Re: Planning Application AW/136/22/HH - 8 St Richard's Drive

Please accept this letter ~~is~~ objection to the plans put forward for planning consent for substantial changes to 8, St Richard's Drive.

North (front) elevation | proposed

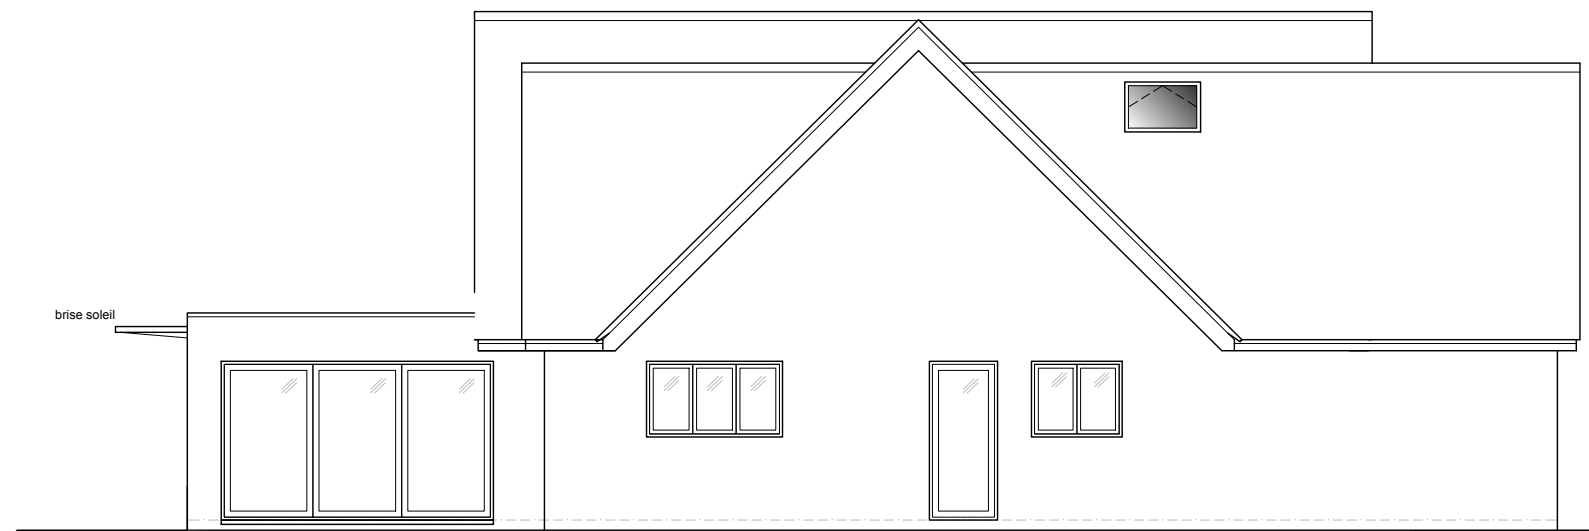
With reference to the *Arun Local Plan 2011-2031 (2018)* I believe the plans submitted do not adhere to policy D DM4. The proposed extension will effectively double the front elevation which means that the extension is not visually subservient to the existing structure (point (b)). The proposed two-storey side extension will have an adverse overbearing effect on the neighbouring property, 10, St Richard's Drive as it will extend to within 1m of the boundary between the properties. The additional shadow cast by the higher roof will have an adverse impact on the light to the study and VVC and, potentially, to the light in the living room, as the plans extend beyond the back exterior wall of number 10. The garden, and specifically the patio area will suffer from overshadowing. With reference to point (e) of the policy, the established spatial character of the street is based on there being a good amount of space between each property. The proposed plans will compromise this characteristic, as the side extension is overly large for the street scene. Whilst the properties on the street are of varying designs, what unites them is that they sit in generous plots and none of the them fill or dominate their plots in the way that the proposals for this property would, given the sheer width of the frontage to the street and its scale and massing.

The scale of the proposals is such that the extension is equally dominant, not subservient to the existing property.

The document goes on to say that "side extensions should in most cases be set back from the front of the house in order to play a subservient role to the original building... Extensions should also in most cases be set down from the existing roof ridge height by a minimum of 0.5 metres,". The side extension proposal in this case is set in front of house to incorporate the existing garage, and the roof ridge across the whole property is proposed to be raised.

Looking again at the proposed front elevation, the first floor will be less than 1m from the boundary, which does not adhere to the Arun design guidelines which state "In streets characterised by small gaps between buildings, extensions must not close important gaps in the street scene by leading to a terracing effect, or remove existing external access from front to back gardens. This can generally be ensured by keeping extensions at least 1 metre away from the side boundary of a plot at ground floor and 2 metres away at first floor and above". The plans will also contravene the next principle "No part of the development should generally protrude further than the 70 degree line taken from the plot boundary" as the proposals extend to a line of around 84 degrees from the plot boundary.
